Chatswood Chase Shopping Centre Table of Response to Submissions

The table below summarises the responds to issues raised as part of the exhibition of the EAR. The table should be read in conjunction with correspondence from WCC dated 8 August 2007 provided in Appendix A.

Scale 1:100

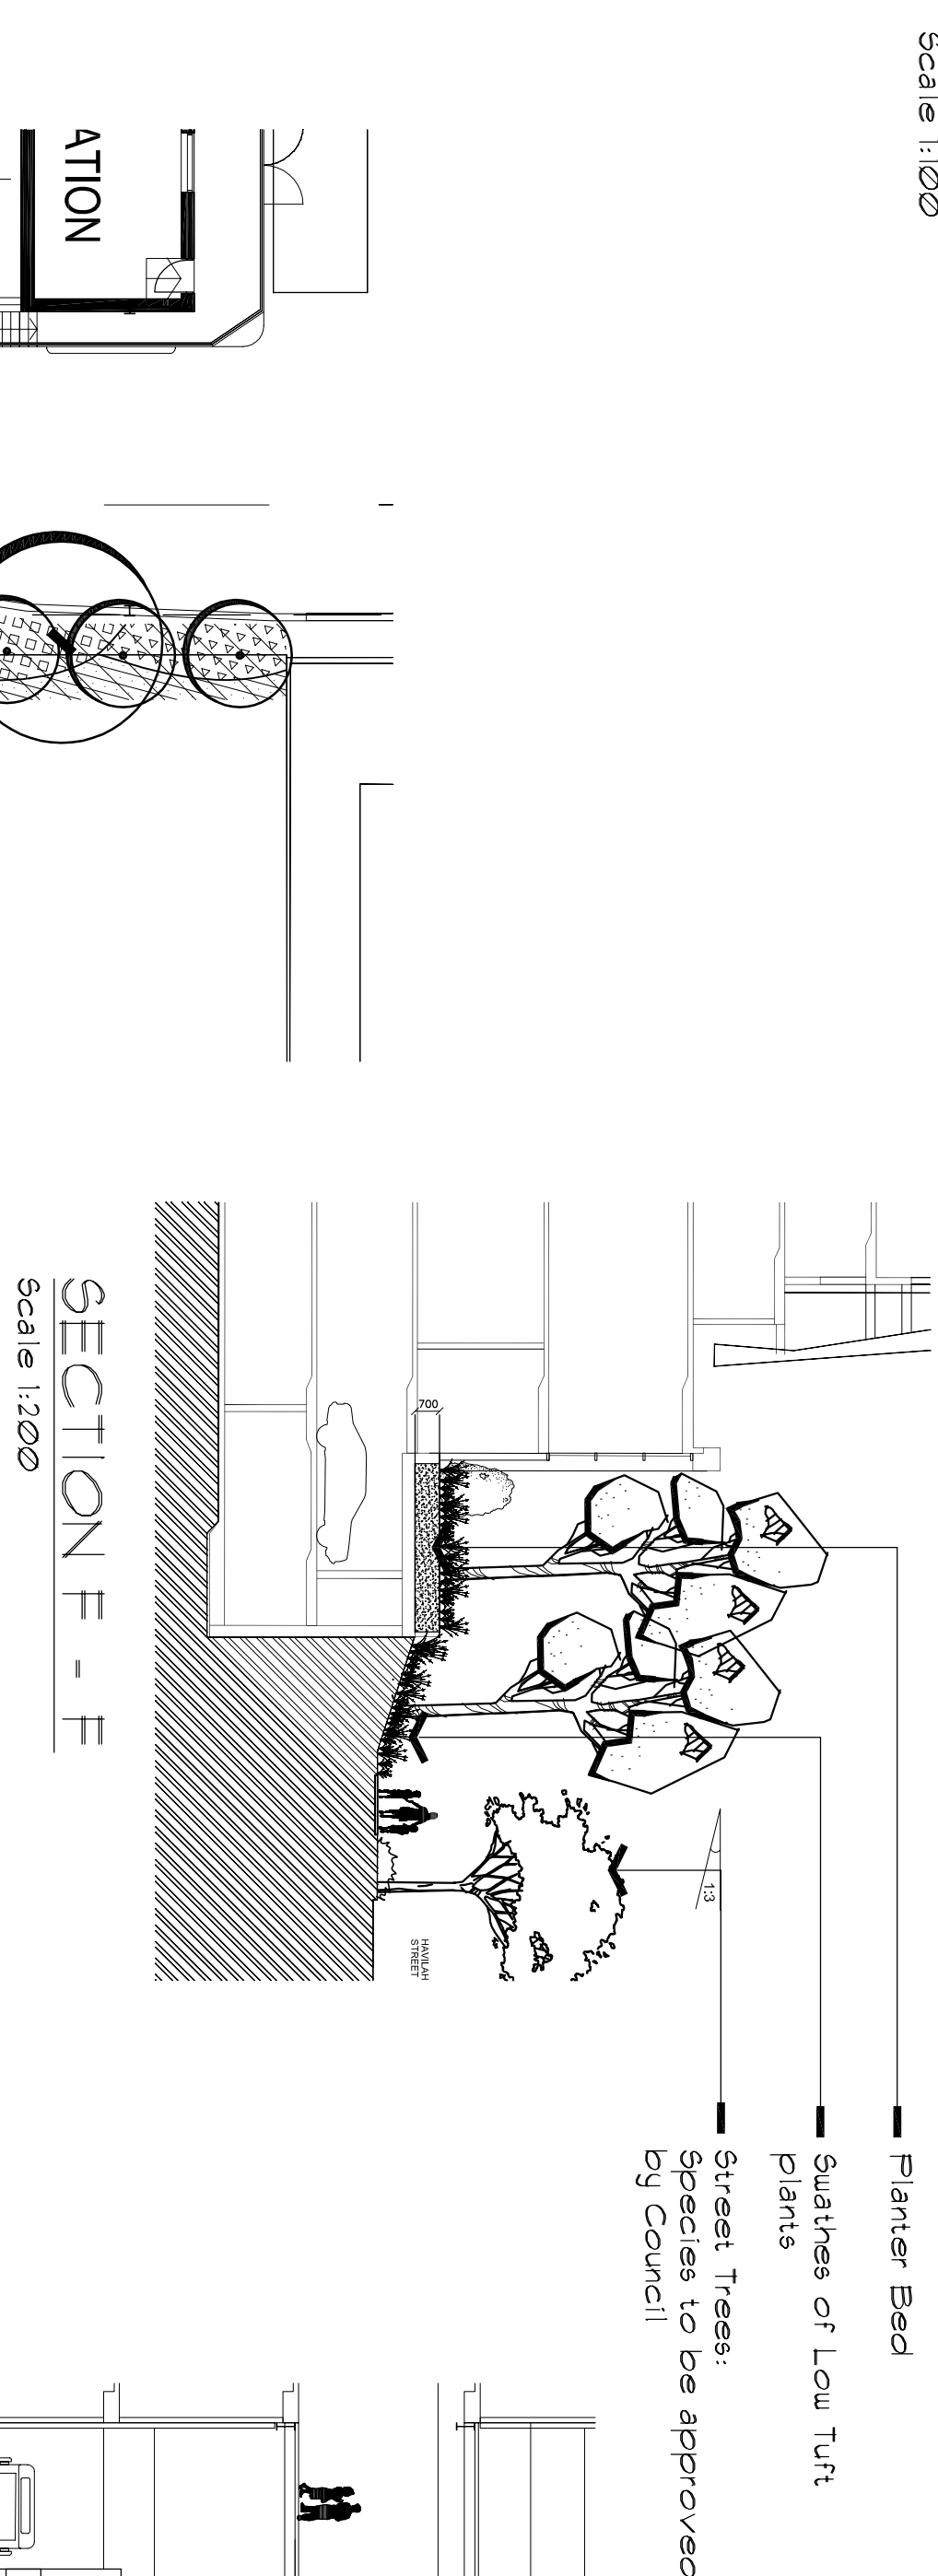
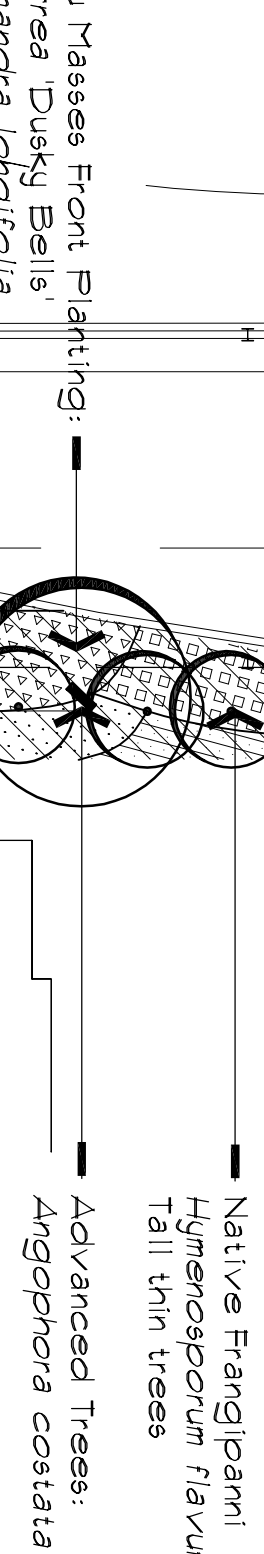
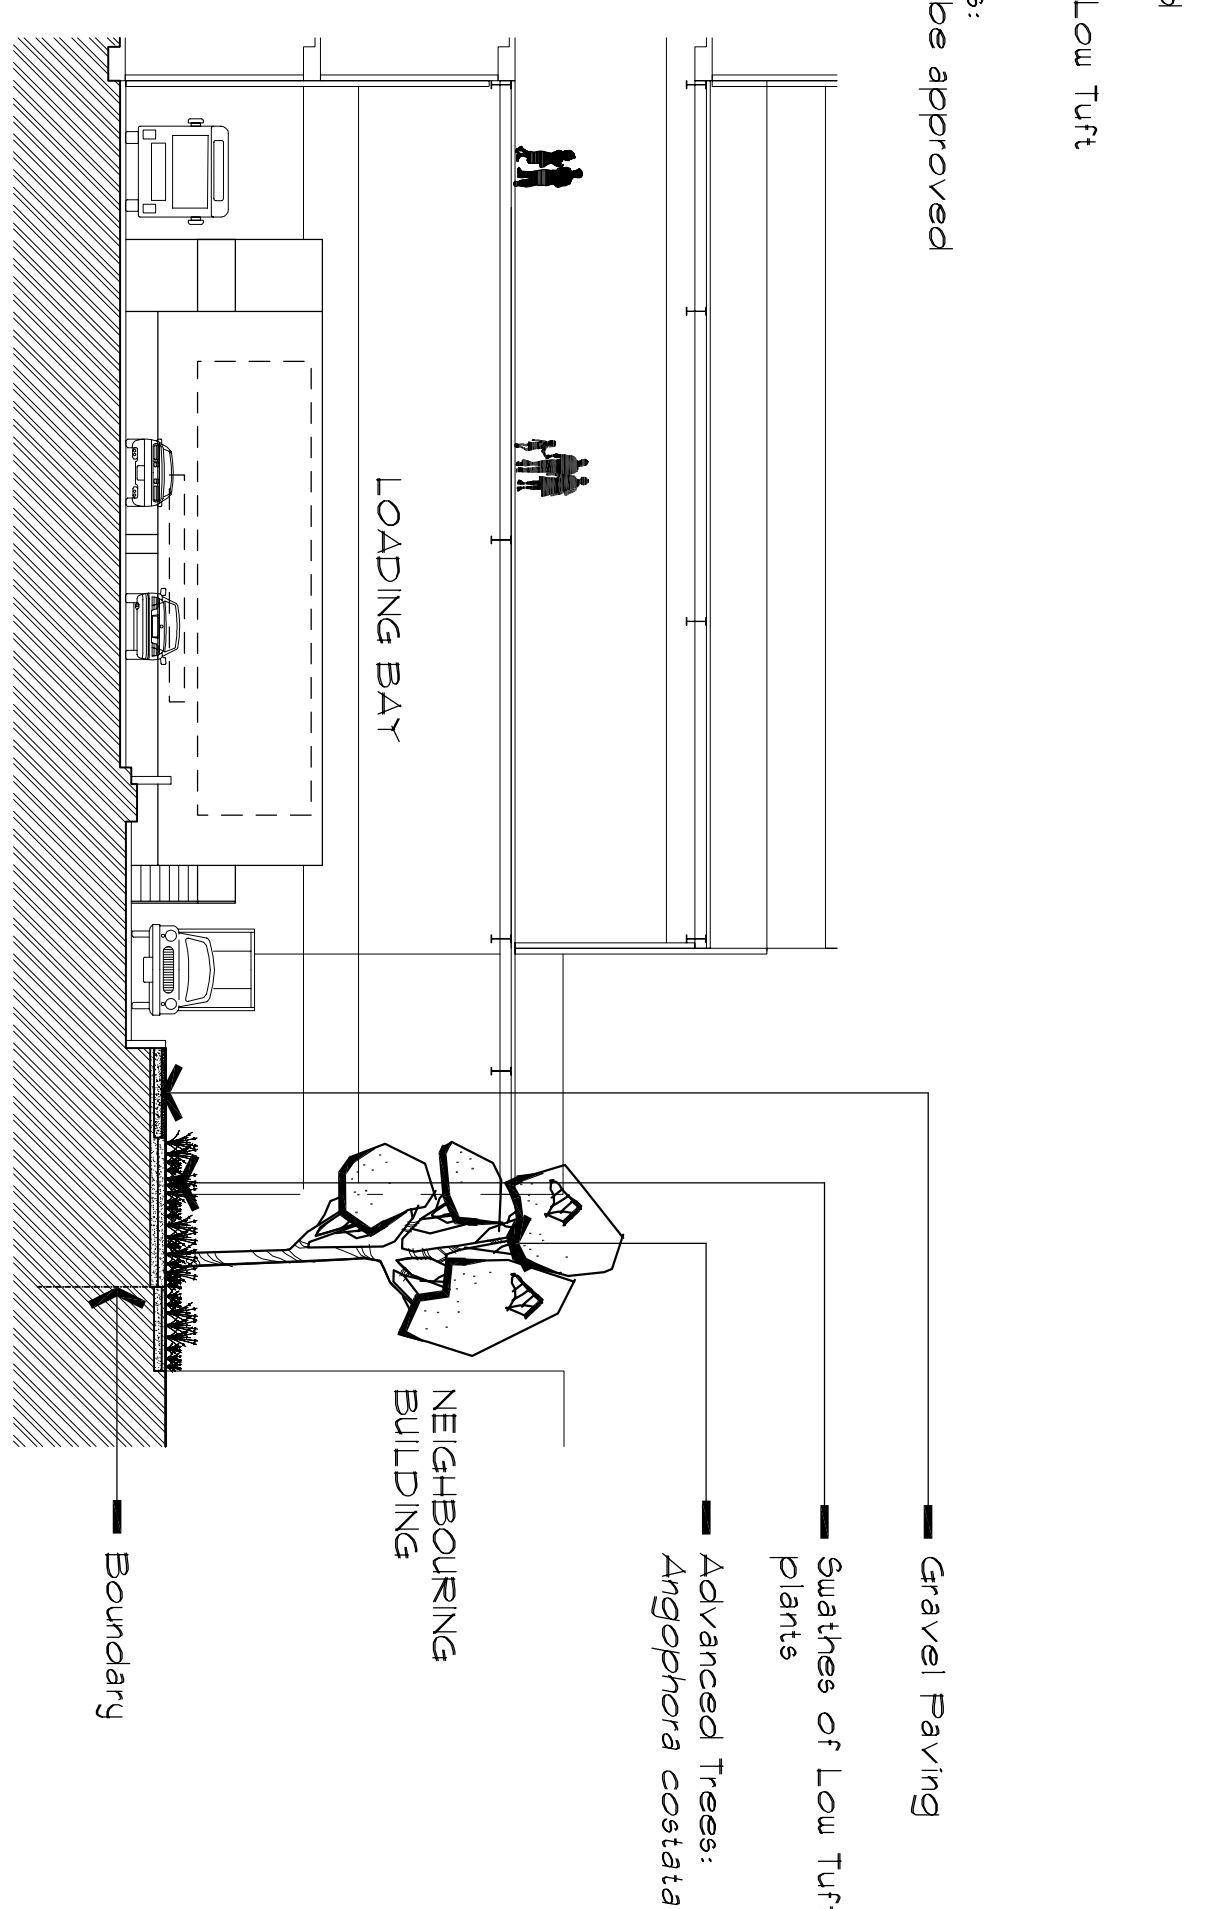
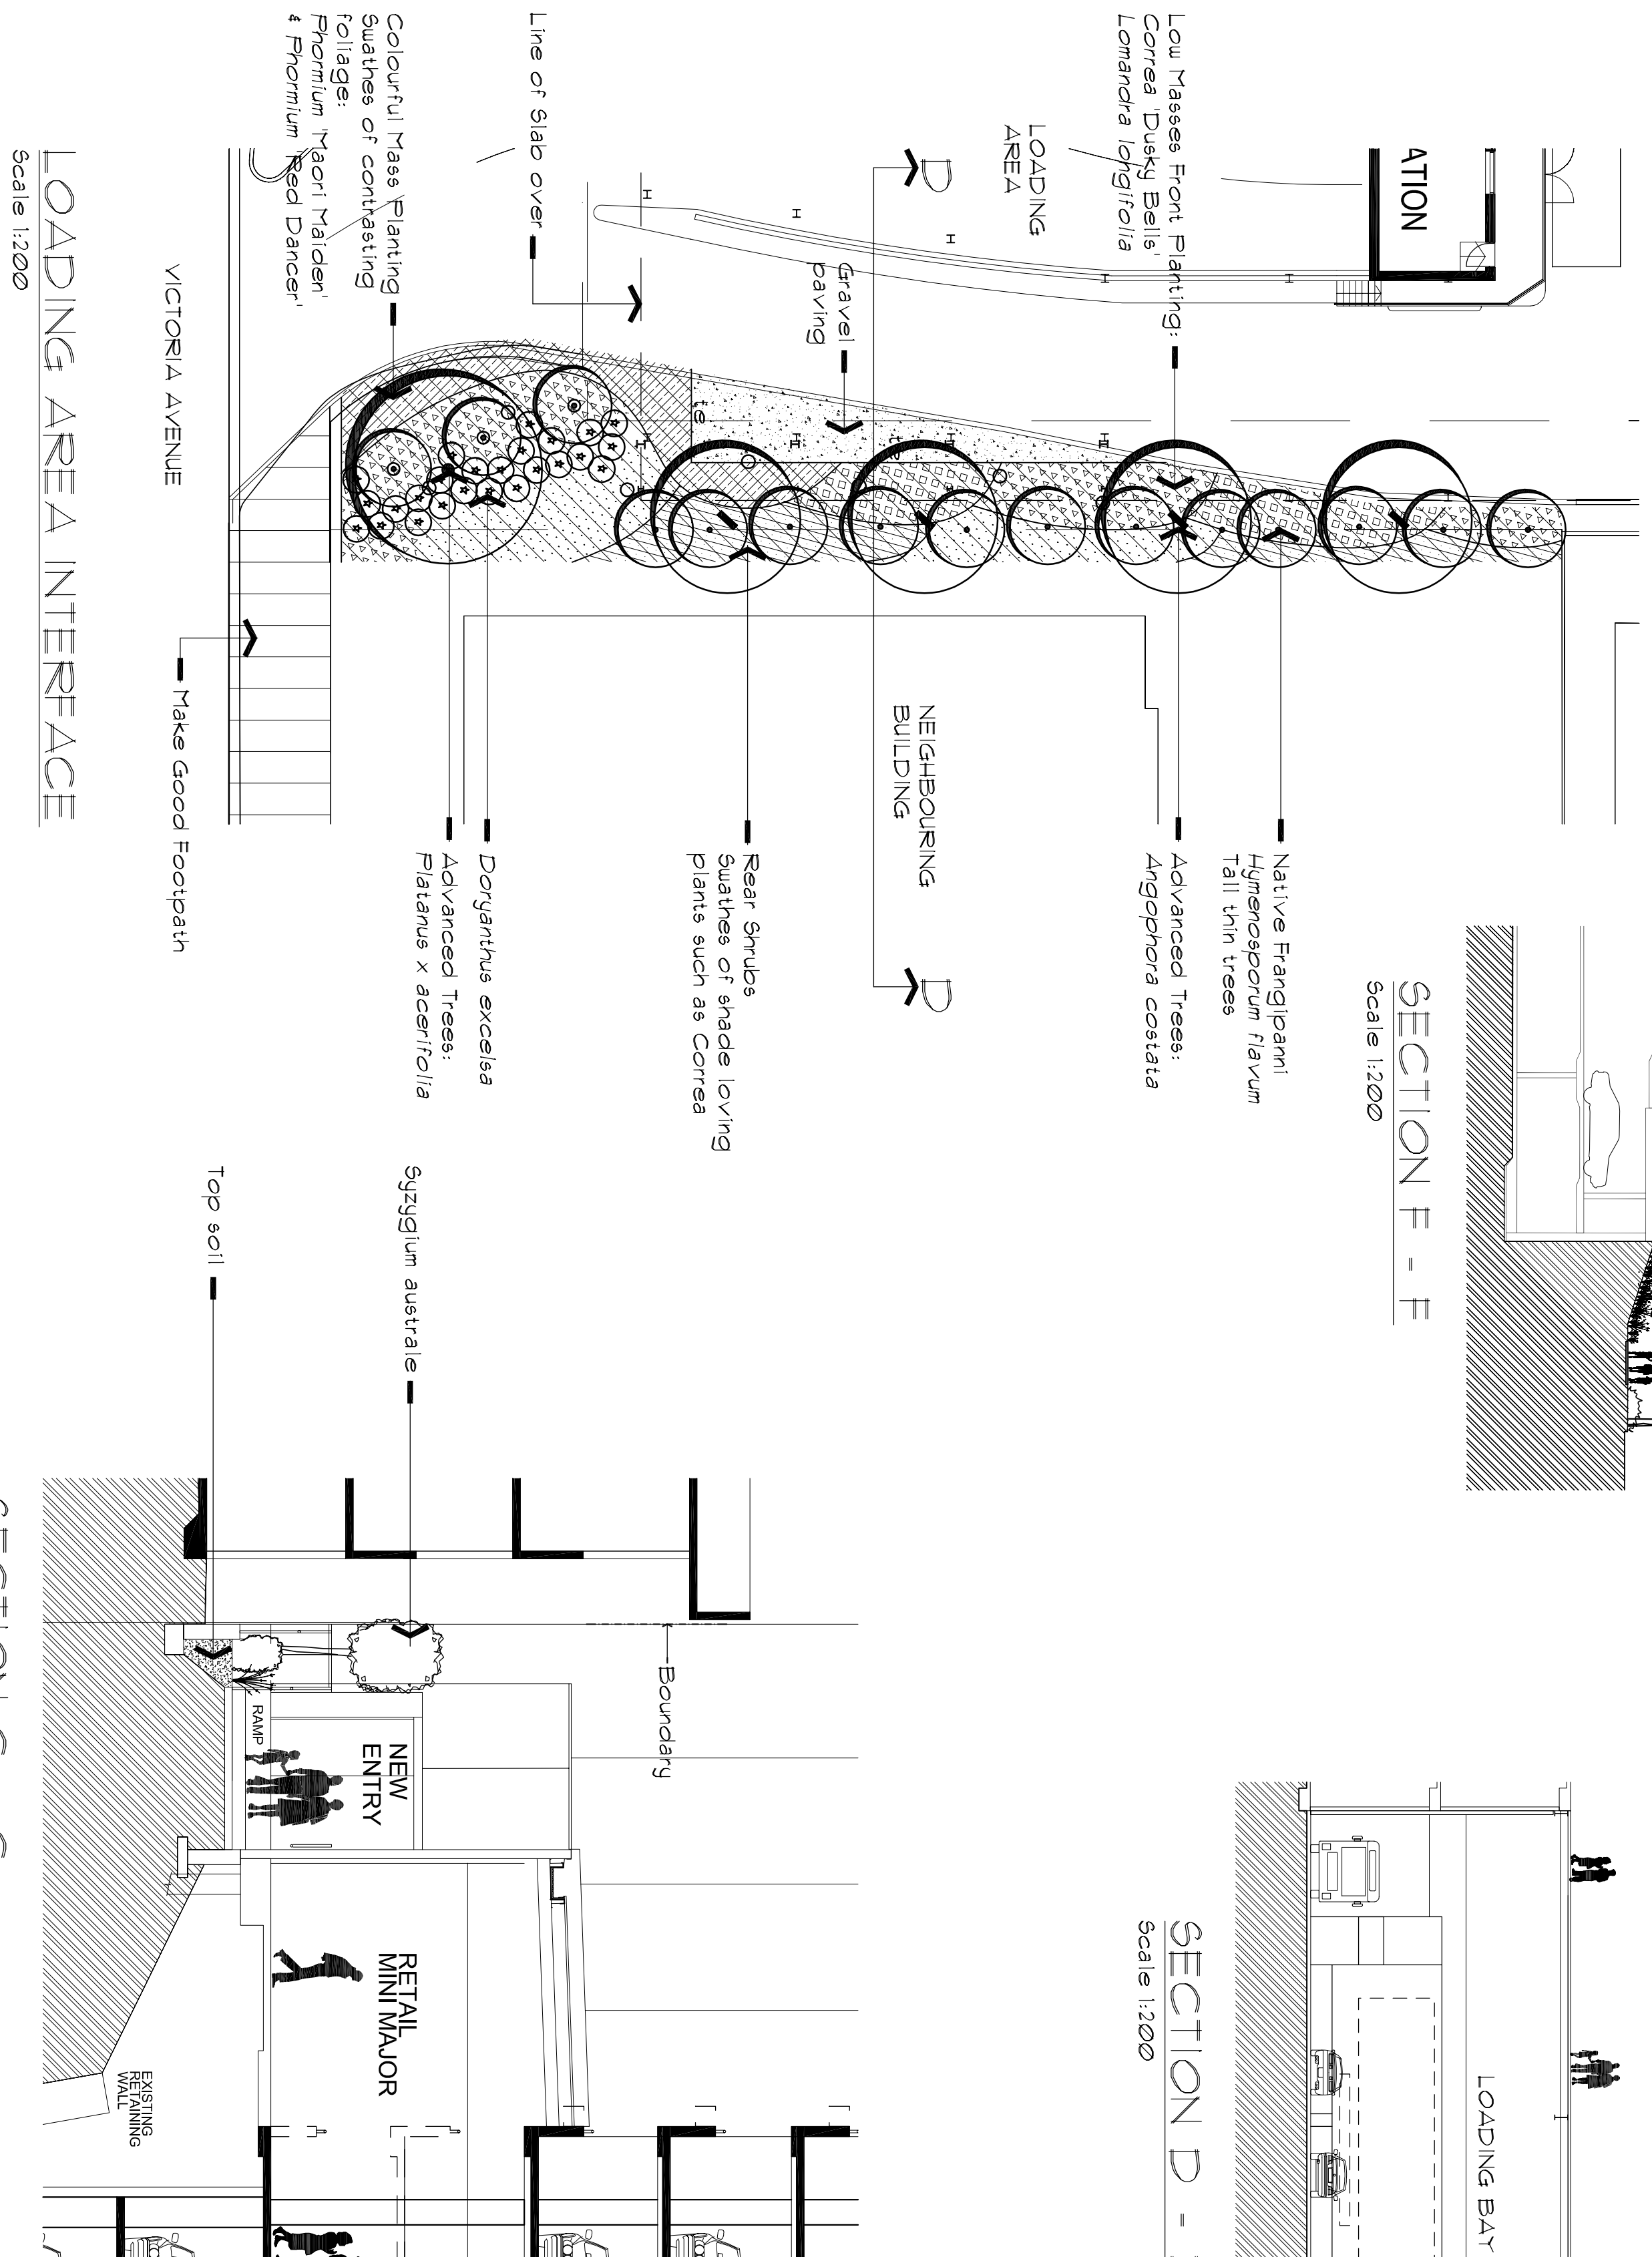
13	<p>At the public meeting, comment was made by your architect that it was expected that there was potential for three of the existing trees in the Havilah Street setback to the existing car park will be retained. Council's Landscape Section requires clarification on this point having regard to the extent of demolition and building works that may impact on the root system of the trees. The clarification needs to carefully consider the species, age and health of the trees noting that if damaged through the demolition/construction process, they may become a danger in the future for pedestrians in the vicinity.</p>	<p>The existing tree screen will be lost during construction. A new integrated landscape installation will be provided from 5-7 Havilah Street around to the boundary with 12-14 Malvern Avenue.</p> <p>Hedge planting and new street trees will be planted to Council requirements along Havilah Street as agreed with Council. Illustrated on updated Landscape Plans, Drawing Numbers 1461-LC1 and 1461-LC2.</p>

14a	<p>Various inconsistencies exist between the landscaped plan and the architectural plans, these require review and clarification. These include:</p>	Updated Landscape Plans provided, Drawing Numbers 1461-LC1 and 1461-LC2.
14b	<p>– Level changes and the need for retaining walls along the boundary with Havilah Street in the architectural plans that do not appear in the landscape plans. Council's expectation is that the interface is seamless with minimal level change and if a change in level is required it is not of a height that requires fencing.</p>	The detailed design to achieve Council's expectation will be addressed prior to issue of the CC for Landscaping.
14c	<p>– A paved pathway from Malvern Avenue enters that site to the building but its purpose is unknown.</p>	Stepping stone pavers have been provided where access is required to switchrooms.
